From: Laura Gibbons <[REDACTED]>
Sent: 02 November 2021 09:02
To: Planning.Responses <[REDACTED]>
Cc: Anita Gardner <[REDACTED]>
Subject: RE: Planning Consultation on: CM/46/21/PL

Application No: CM/46/21/PL
Registered: 20th August 2021
Site Address: Land to the rear of Bairds Farm Shop Crookthorn Lane Climping BN17 5SN
Grid Reference: 499956 101760
Description of Works: Variation of conditions following grant of APP/C3810/W/19/3227274 (CM/16/18/PL) relating to Condition Nos 2 - approved plans, 3 - Construction & Environmental Management Plan, 4 - tree protection & retention, 5 surface water drainage and 9 - car parking.

Proposed Site Plan

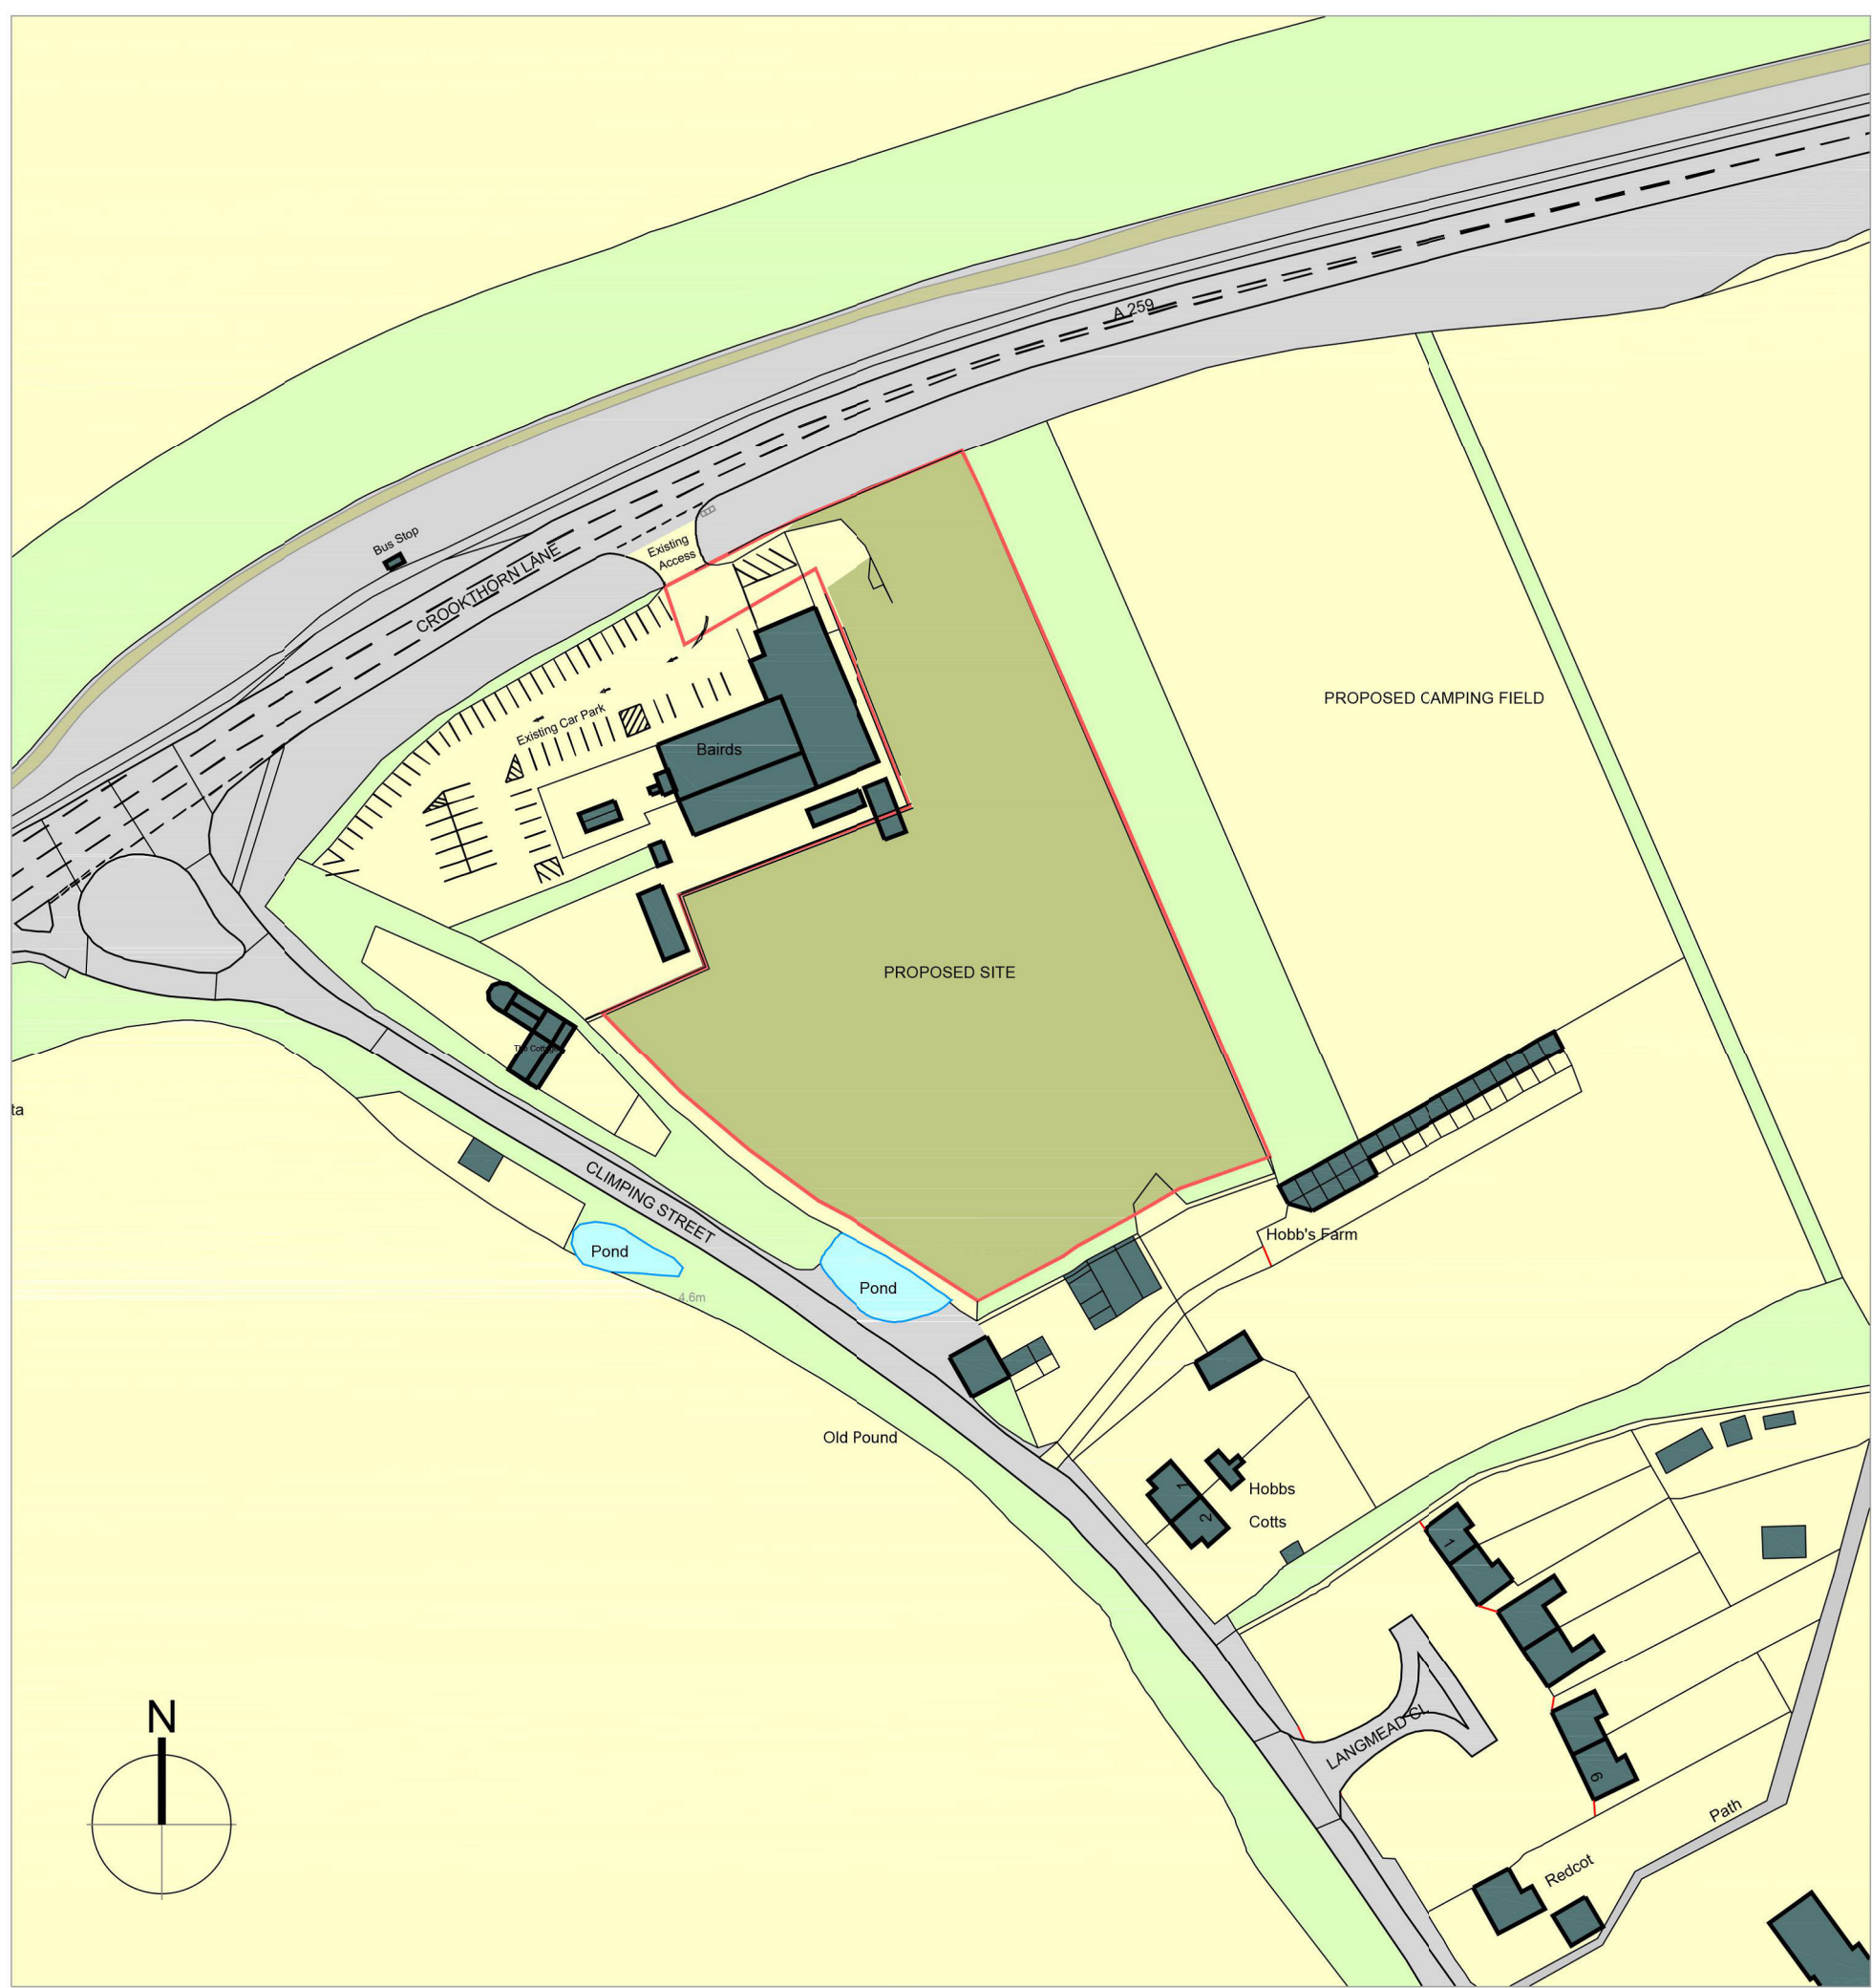
Thank you for consulting us on this application to vary condition 5. We are unclear on how the proposed change is suitable when it would result in a reference to a layout which is proposed to be superseded. If the revised layout is approved this would result in it being impossible to implement the drainage strategy in accordance with the currently approved strategy. The applicant should submit a revised surface water drainage layout which reflects the proposed changes to the layout.
